To: **Kenny Gwinn**
KB Home
4506 S Miami Blvd
Durham, NC 27703
kgwinn@kbhome.com
919-592-2624

Re: **Foundation Item**
Location: Lot 12 Highland Grove (364 Windy Farm Dr. Fuquay-Varina, NC)
JDS Project No.: RDU2111200
Date of Inspection: 10/14/2021

Observations

**CRAWL SPACE FOUNDATION PLAN - 'C'**  
 SCALE: 1/8"=1'-0"

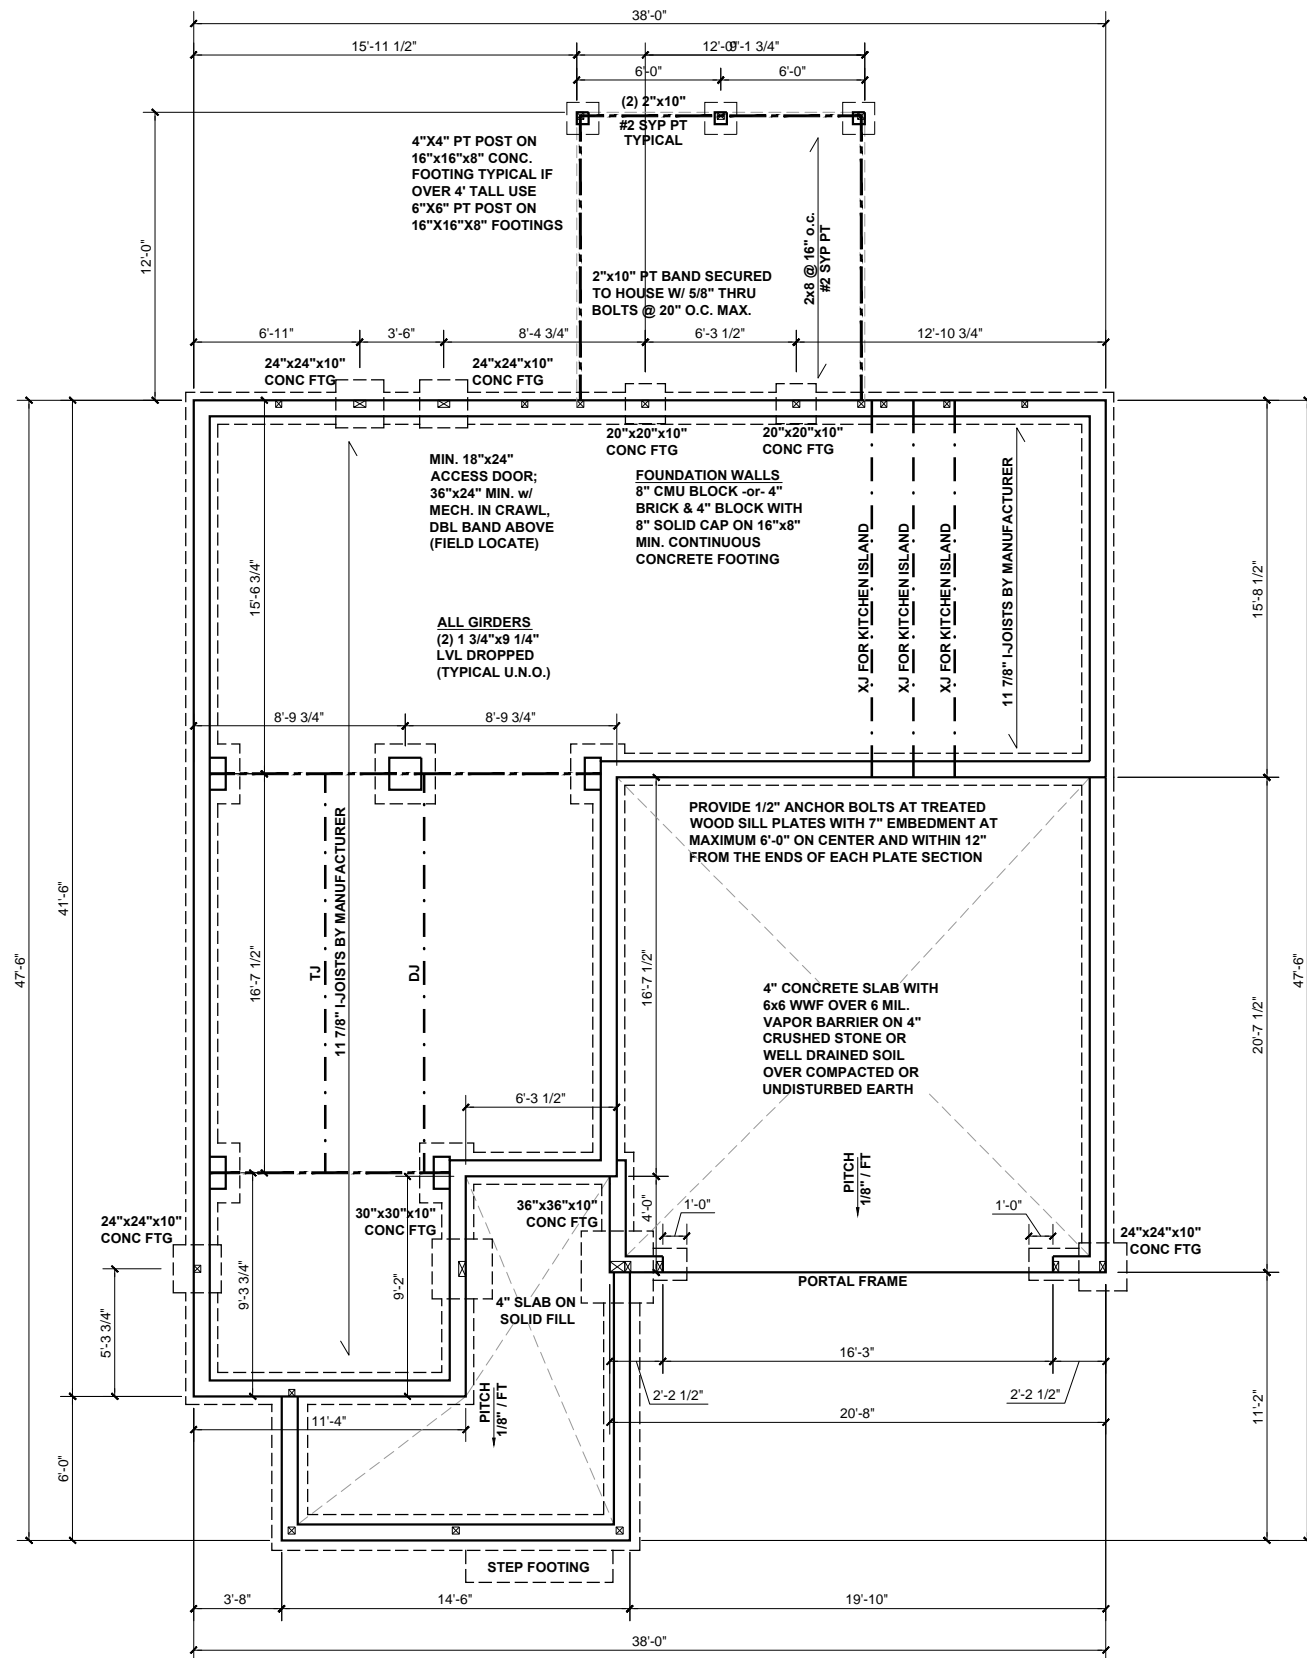
The 5/8" threaded rods at the garage wing walls were installed off center. (2) Red Heads were installed at each wing wall.

Based on our on-site observations and review, this repair is not adequate. The contractor has (2) repair options.

1. Reinstall (2) 5/8" threaded rods by drilling through the wing walls to dowel and epoxy them minimum 6" into the footings. Ensure the total threaded rod length is document prior to installing them into the footing to ensure adequate embedment depth.
2. Drill directly behind the existing 5/8" threaded rods (approximately 8") and bend the threaded rods toward the center of the wing walls enough to install the required nut and washers. Fill the voids in the concrete where it was drilled with structural epoxy.
